Ref – Planning Application R/64/17/PL for Demolition of 1 No. dwelling & erection of 4 no. dwellings, at St. Mary's Close, Hurst Road, Rustington.

Further to our previous objection dated 14th May, we would like to restate our **objection** to the amended plans for St Mary's Close. Whilst we recognise the revisions attempt to address one of our concerns in relation to the location of the garage blocks, the amendments introduce further issues in relation to density and the character and appearance of the development, both of which were the primary reasons for our initial objection.

TITLE	SITE SURVEY
1. <u>General Information</u>	
2. <u>Site Description</u>	
3. <u>Survey Methodology</u>	
4. <u>Data Collection</u>	
5. <u>Analysis and Results</u>	
6. <u>Conclusions and Recommendations</u>	
7. <u>Appendices</u>	
8. <u>References</u>	
9. <u>Other Information</u>

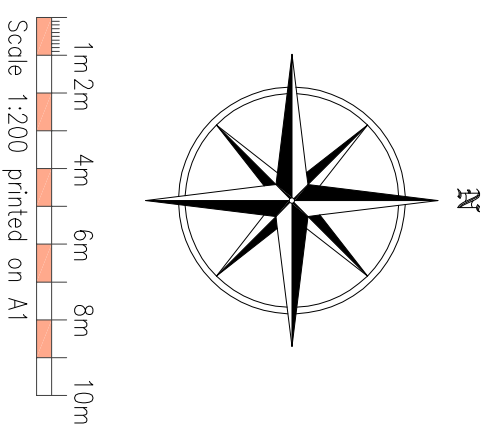
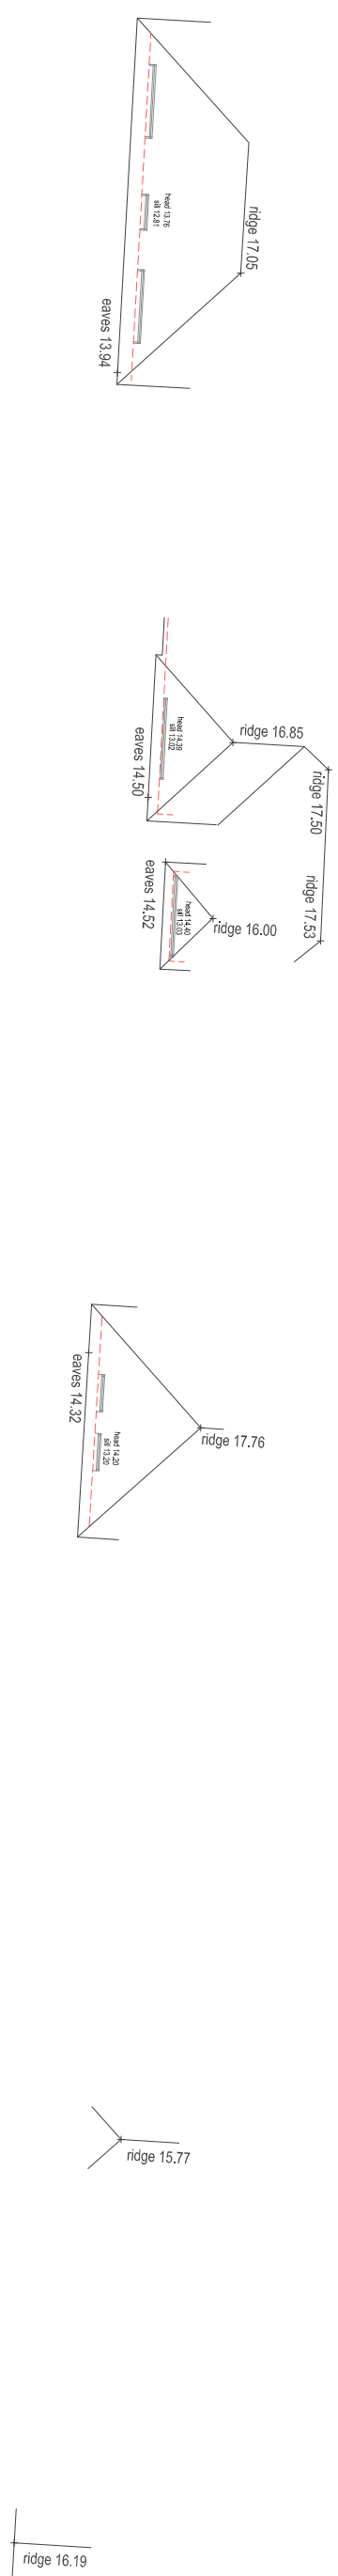
- In several places, the letter refers to the '*retention of the existing building line*' but clearly this isn't correct as demonstrated previously;
- The Landscaping and Trees sections talks about preserving trees and states that '*all existing trees in the rear garden will be retained*'. The Site Survey Plan drawing ref P1017 shows several trees and hedges that will clearly have to be removed during the construction phase;

Drg No: 151117_SS-01 Rev: D

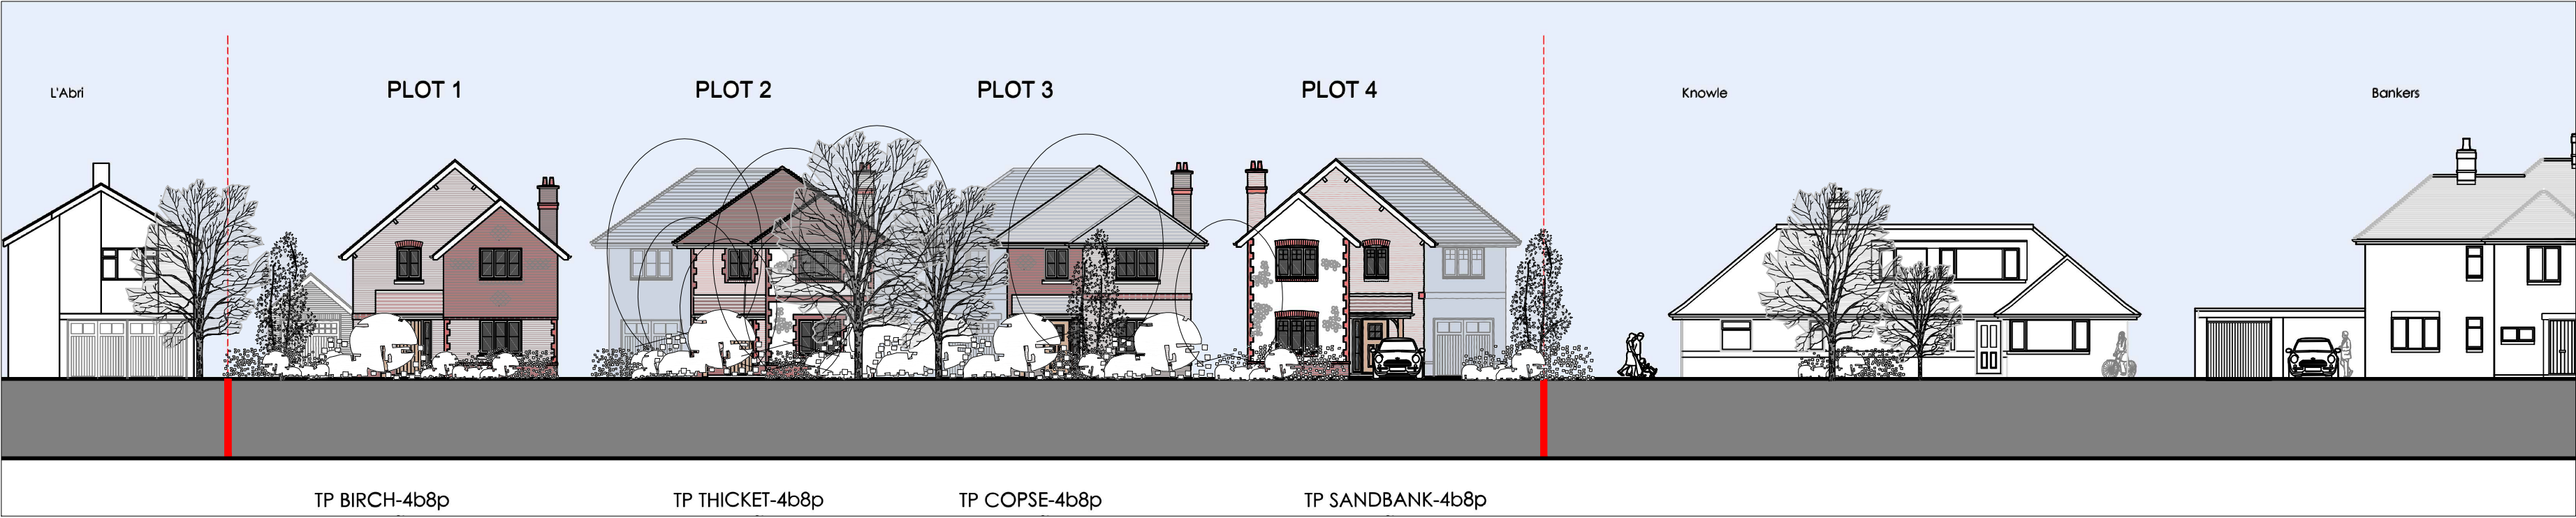
- There is a significant lack of dimensions leaving the development wide open to change if implemented;
- The architect has cleverly shaded out the rear portions of plots 2 and 3 to create an optical illusion of space between the properties;
- There appear to be several inconsistencies between the plans and elevations which again create the illusion of space. The following two extracts demonstrate how the spacing between plots 2 and 3 vary between the drawings, with the plan showing approx 2m and the elevation showing as little as 600mm between the eaves (measurements scaled as none provided on drawings);
